## Engineers Comments Regarding Surface Water Drainage

| <b>Application Reference:</b>   | WA/39/26/DOC                                                                                                                                                        | <b>Reviewer Reference:</b> | ADC/EXT2   |
| <b>Site Name:</b>               | Longacres Eastergate Lane Walberton BN18 0BA                                                                                                                        |                            |            |
| <b>Application Description:</b> | Approval of details reserved by condition imposed under WA/44/25/PL relating to conditions <b>3-surface water drainage and 4-discharge of flows to watercourses</b> |                            |            |

TREE PROTECTION PLAN

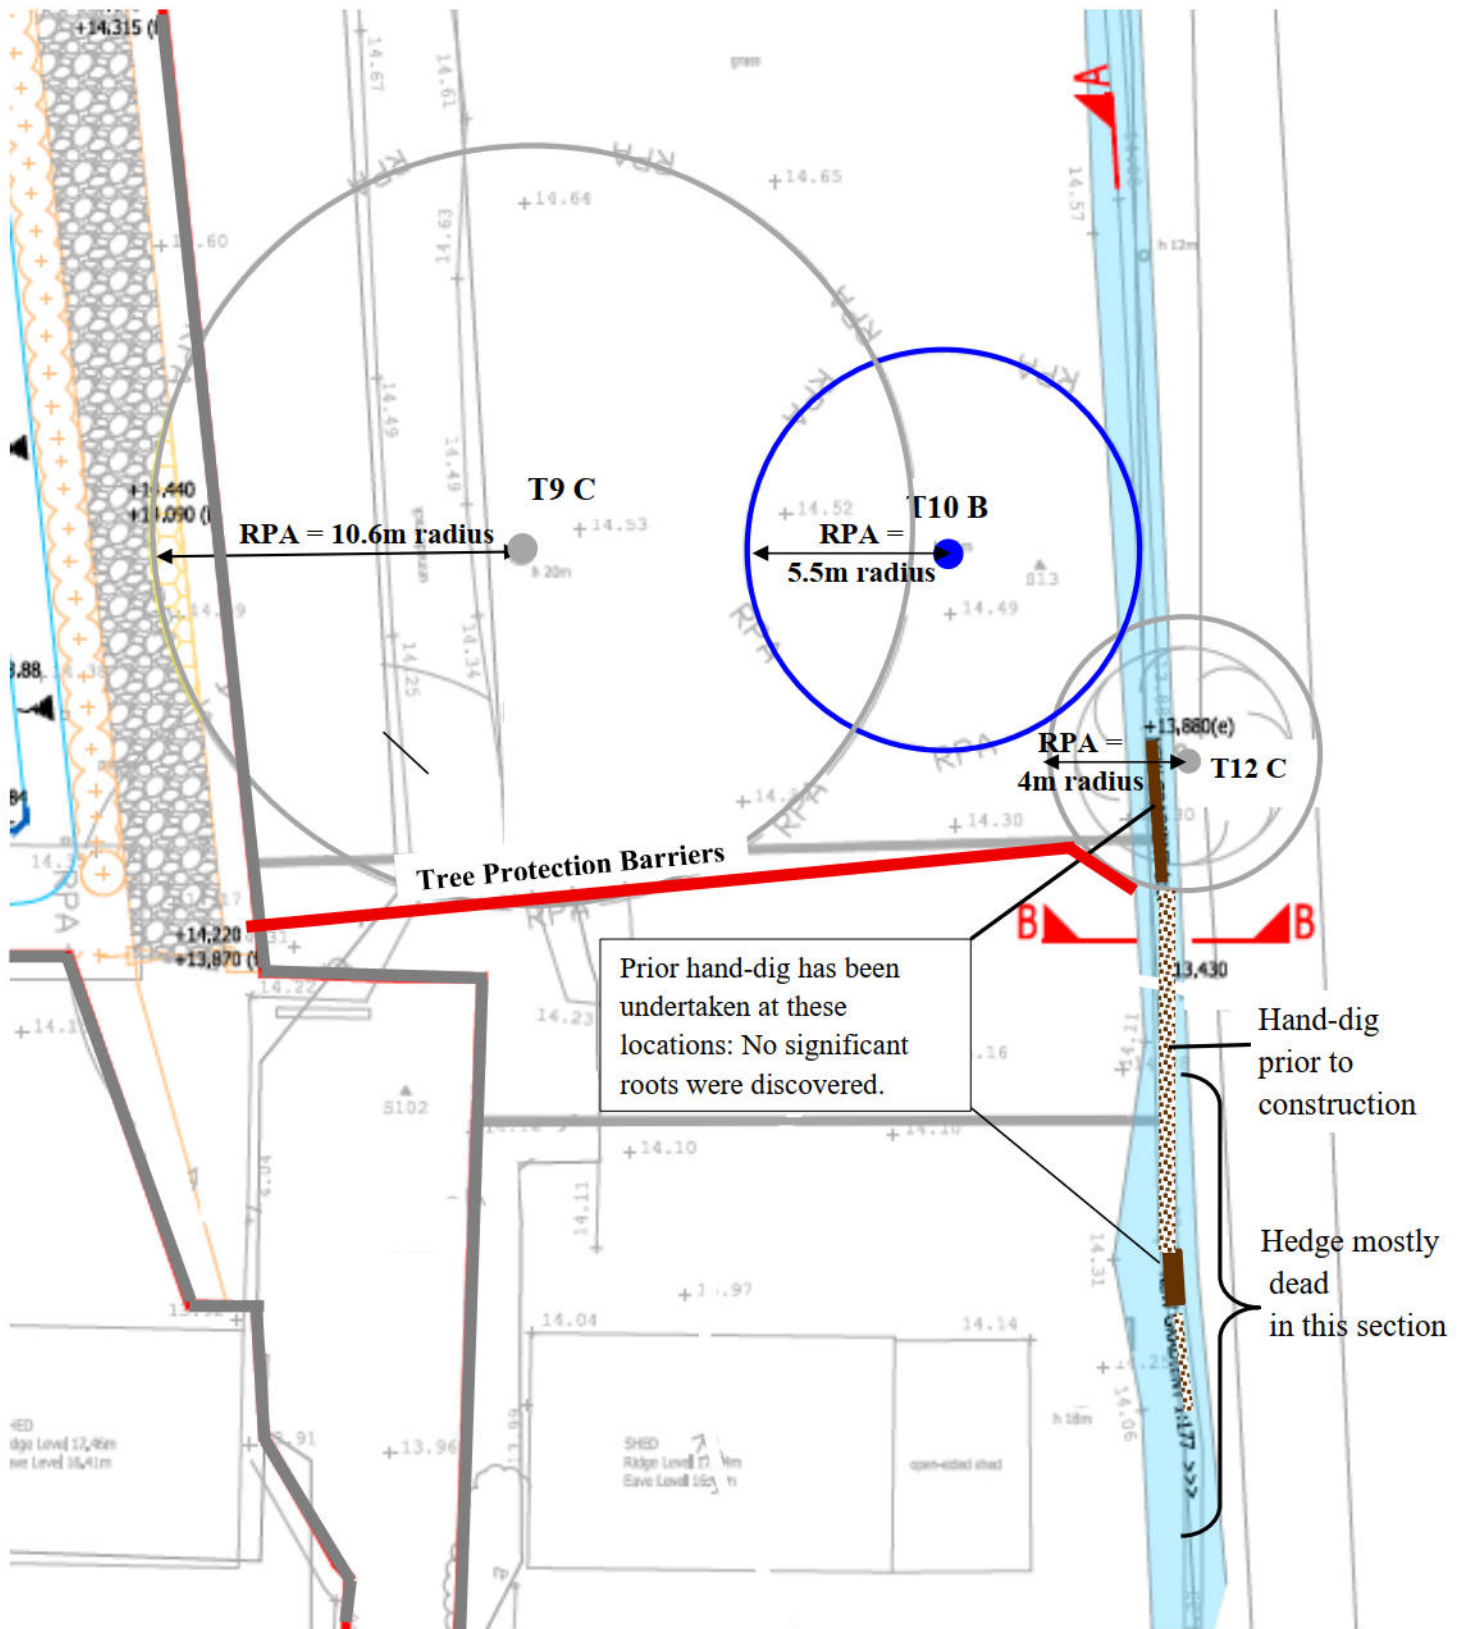
| 6.                         | Please provide evidence that where the works are close to existing trees, arboriculture advice has been sought and adhered to.                  |  |  |  |  |
